EL PASO COUNTY STORMWATER MANAGEMENT PLAN CHECKLIST

EPC Project Number: PPR-21-038 fix overlap

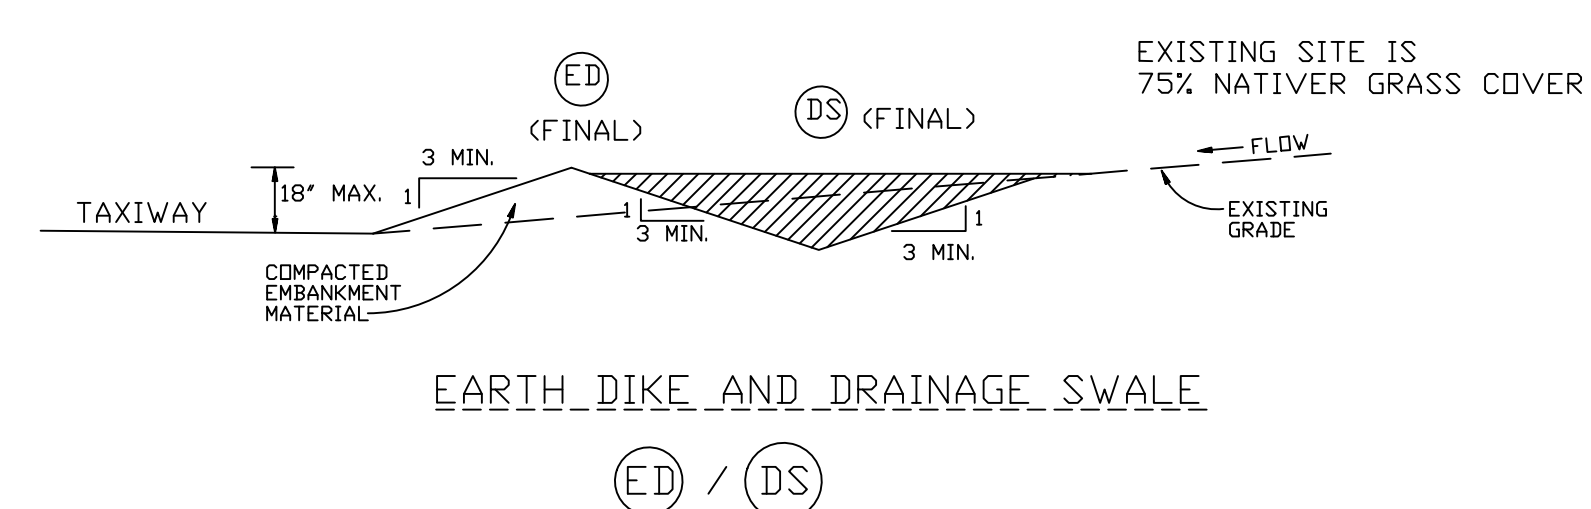
Applicant	EPC
17	SWMP Map to include:		
17a	construction site boundaries	x	✗
17b	flow arrows to depict stormwater flow directions	x	✓
17c	all areas of disturbance	x	✓
17d	areas of cut and fill	x	✓
17e	areas used for storage of building materials, soils (stockpiles) or wastes	x	✓
17f	location of any dedicated asphalt / concrete batch plants	x	✓
17g	location of all structural control measures	x	✗
17h	location of all non-structural control measures	x	✗
17i	springs, streams, wetlands and other surface waters, including areas that require maintenance of pre-existing vegetation within 50 feet of a receiving water	x	✗
18	Narrative description of all structural control measures to be used. Modifications to EPC standard control measures must meet or exceed County-approved details	x	✓
19	Description of all non-structural control measures to be used including seeding, mulching, protection of existing vegetation, site watering, sod placement, etc.	x	✓

TEMPORARY SILTATION BASIN DETAILS

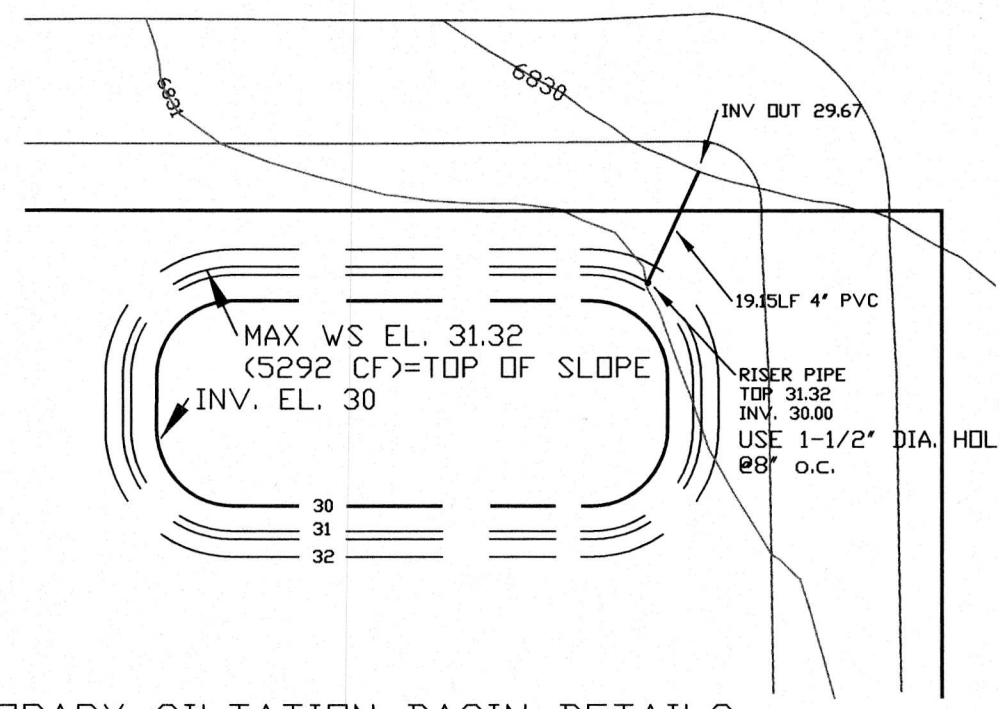
20	Technical drawing details for all control measure installation and maintenance; custom or other jurisdiction's details used must meet or exceed EPC standards missing TSB details	x	✗
21	Procedure describing how the SWMP is to be revised	x	✓
22	Description of Final Stabilization and Long-term Stormwater Quality (describe nonstructural and structural measures to control SW pollutants after construction operations have been completed, including detention, water quality control measure etc.)	x	✓
23	Specification that final vegetative cover density is to be 70% of pre-disturbed levels	x	✓
24	Outline of permit holder inspection procedures to install, maintain, and effectively operate control measures to manage erosion and sediment	x	✓
25	Record keeping procedures identified to include signature on inspection logs and location of SWMP records on-site	x	✓
26	If this project relies on control measures owned or operated by another entity, a documented agreement must be included in the SWMP that identifies location, installation and design specifications, and maintenance requirements and responsibility of the control measure(s)		✓
